From: "Rebecca Eveleigh" <reveleigh@kmc.nsw.gov.au>
To: "Mark Brown" <Mark.Brown@planning.nsw.gov.au>
CC: "Walter Gordon" <walterg@meriton.com.au>
Date: 9/22/2011 2:32 pm
Subject: MP_0057 MOD 1 - comments to amended information

Condition B5 - Amendment not supported

Condition D1 - Modified condition subject to wording provided

Project/Event:	RESIDENTIAL DEVELOPMENT				
Location:	132-138 KILLEATON STREET, ST IVES NSW				
Client :	MERITON				
Plan No.	NRSP9452	A	Date:	25TH MAY 2011	
SCALE: NOT TO SCALE

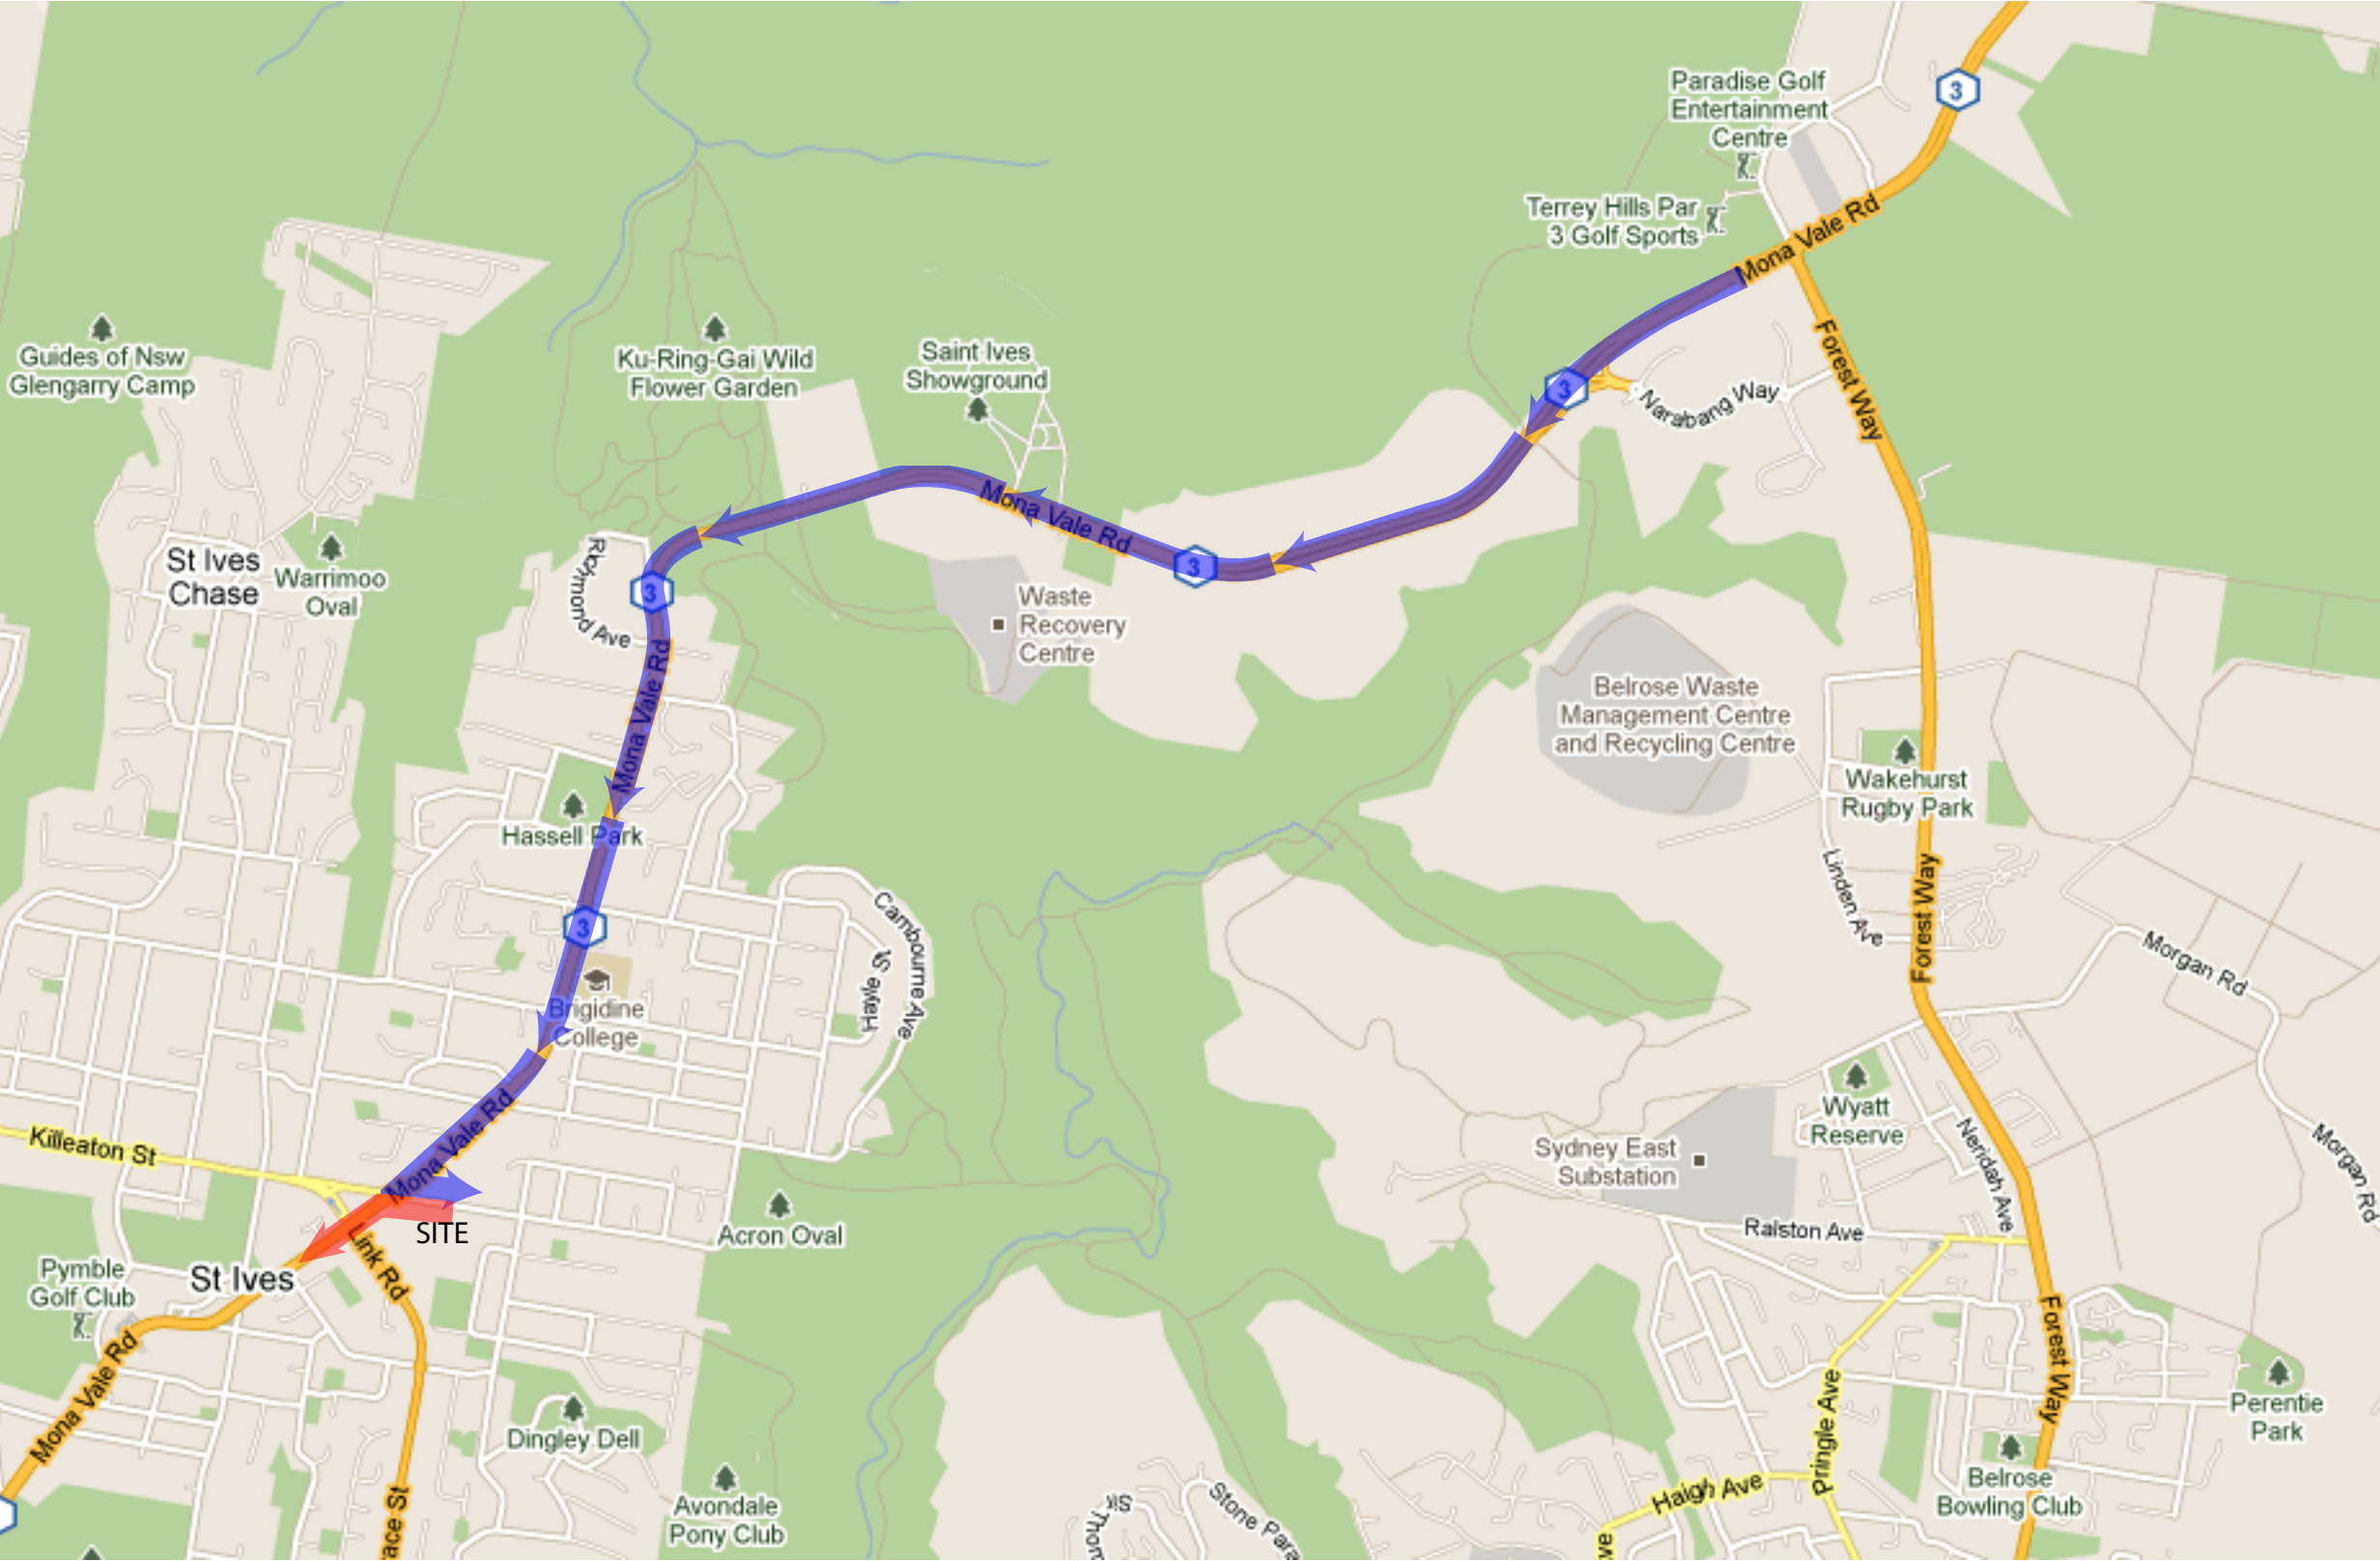
Deletion of the words "No vehicles larger than a small rigid truck are to travel in Killeaton Street east of the site entrance and exit" from Condition B5 is not supported by Council.

Project/Event:	RESIDENTIAL DEVELOPMENT			
Location:	132-138 KILLEATON STREET, ST IVES NSW			
Client :	MERITON			
Plan No.	NRSP9472	A	Date:	28TH JUNE 2011
SCALE: NOT TO SCALE

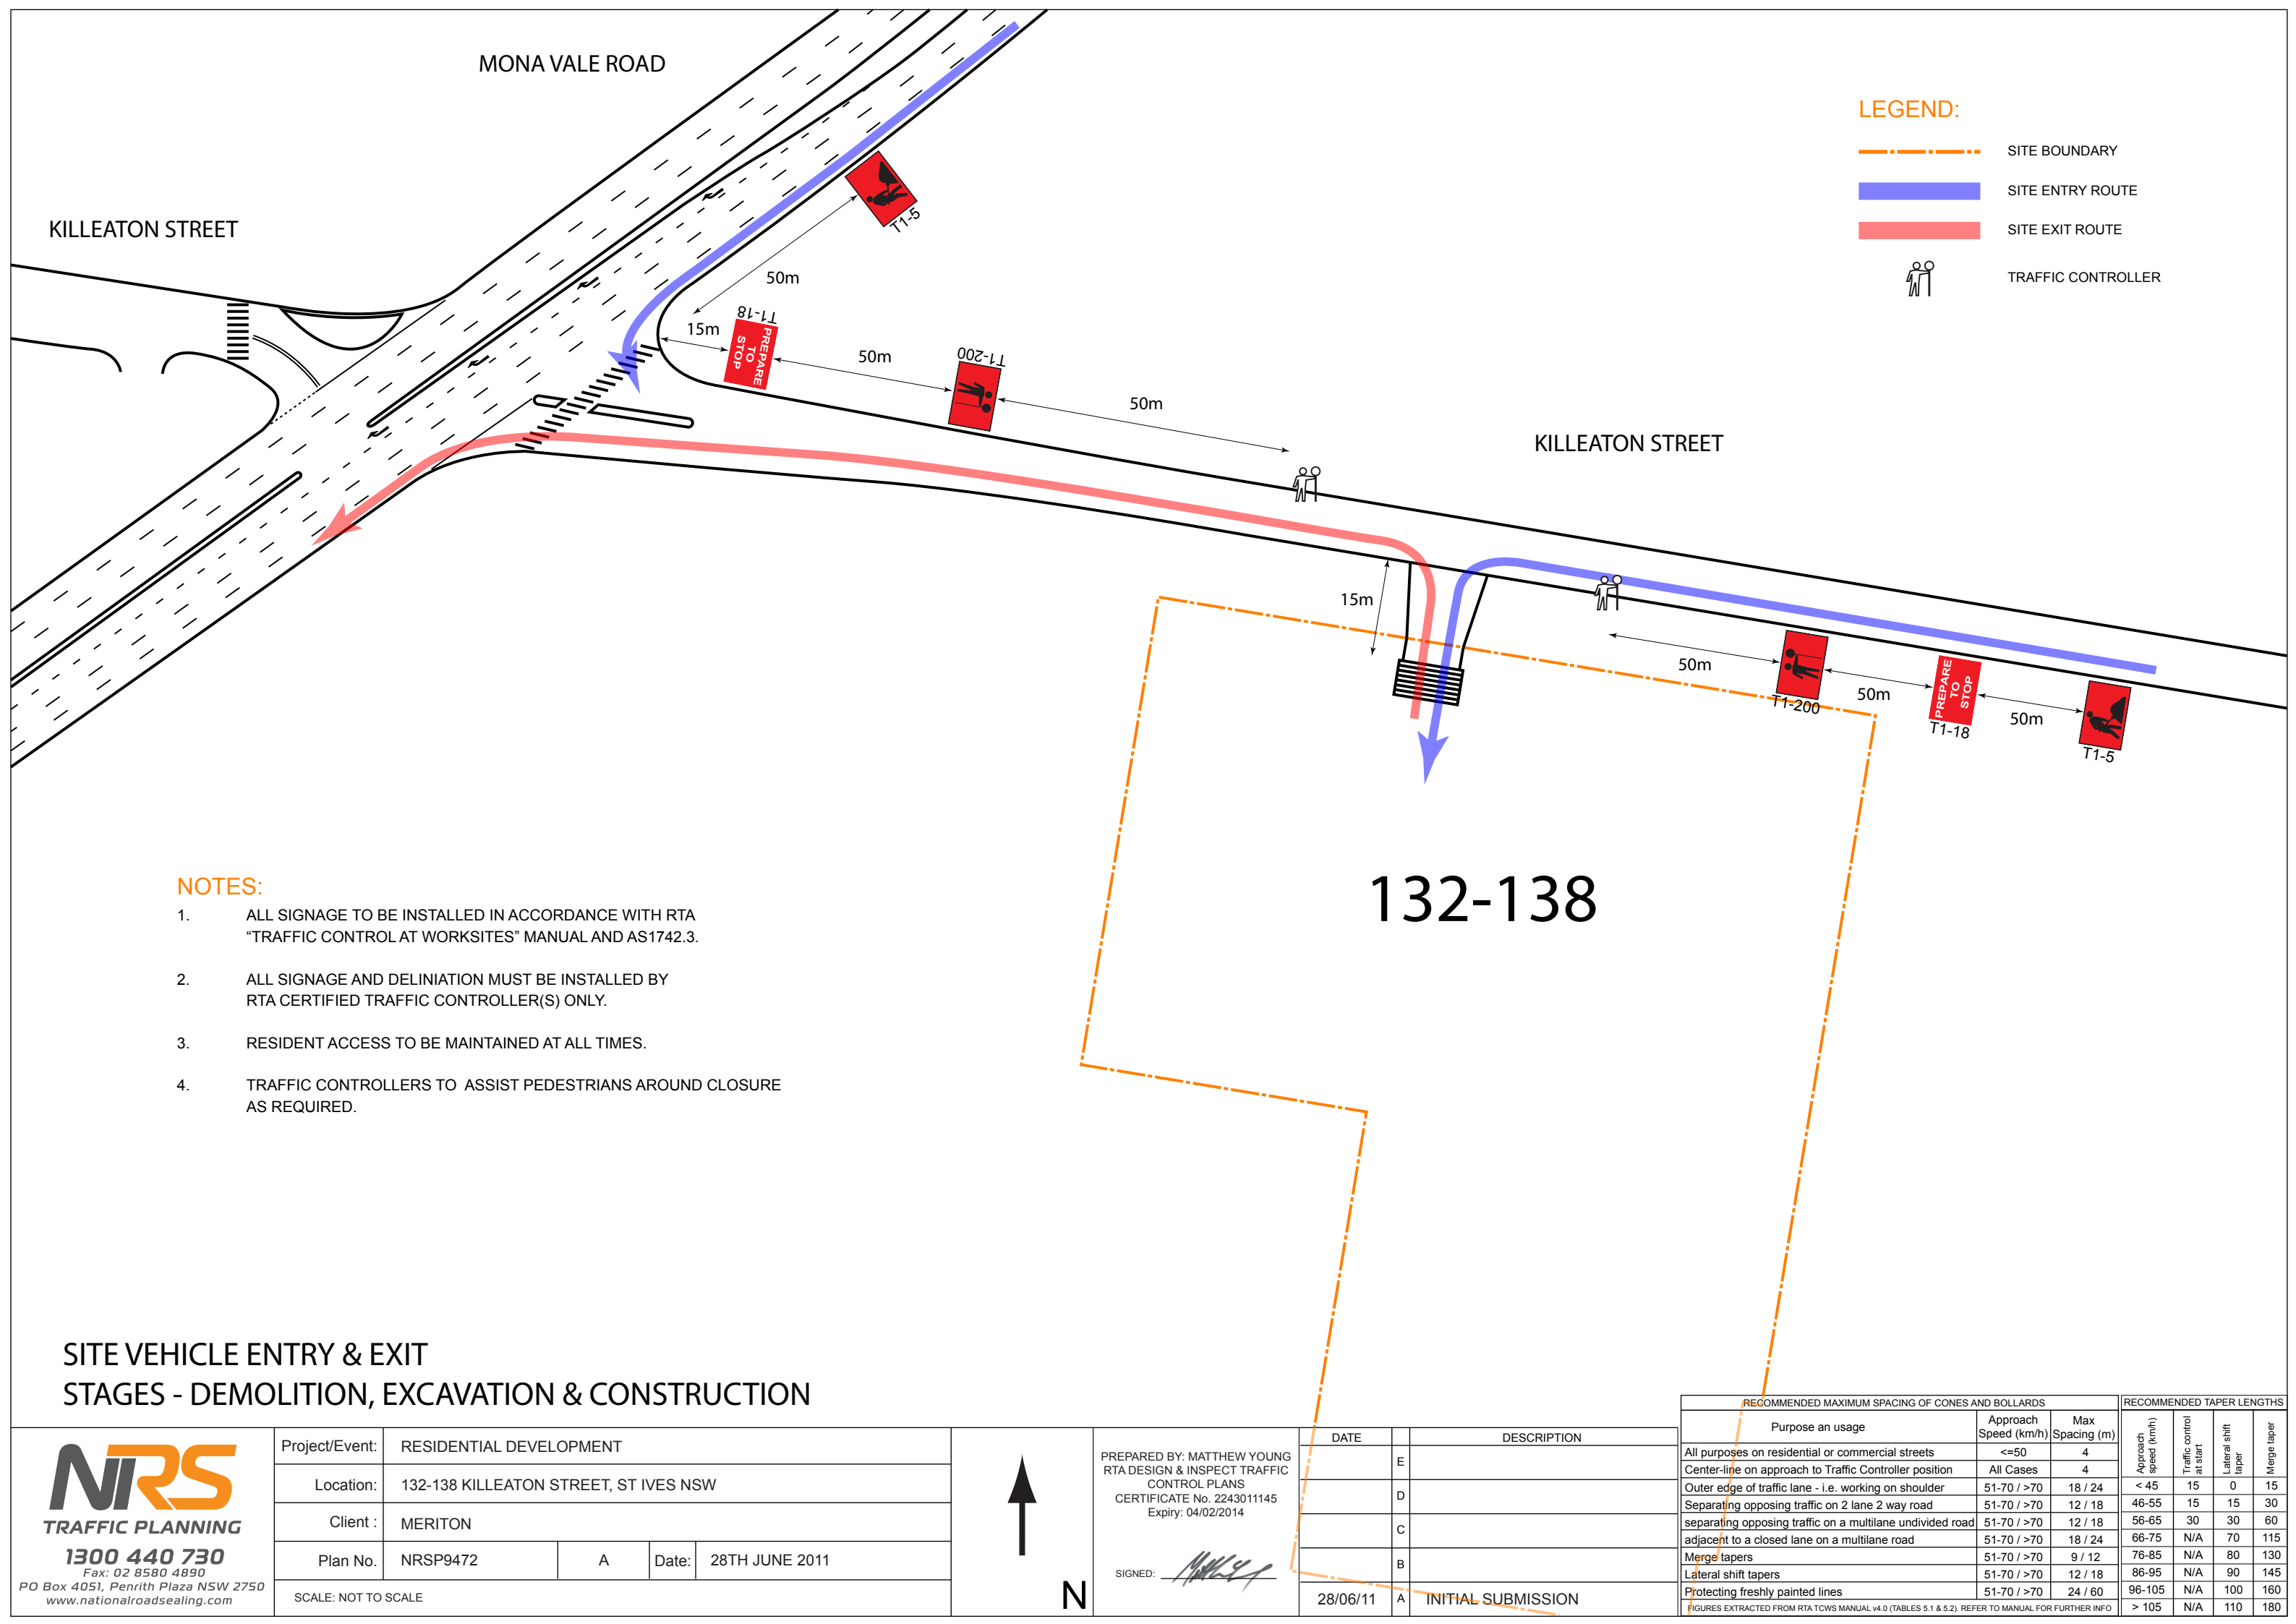
The amended Construction Traffic Management Plan (CTMP) by NRS Traffic Planning, NRSP9451 R3, dated 31 August 2011, would not be approved by Council. The following matters need to be resolved:

1. The CTMP still shows the access via the existing driveway which is prohibited by Condition D1.
2. Stanley Street between Horace Street and Yarrabung Road, a residential street, does not have room for two vehicles to pass when cars are parked either side. How is this to be managed? Parking restrictions are dependent on Council approval and resident feedback. Traffic control in that section may be required. The CTMP should address this issue.
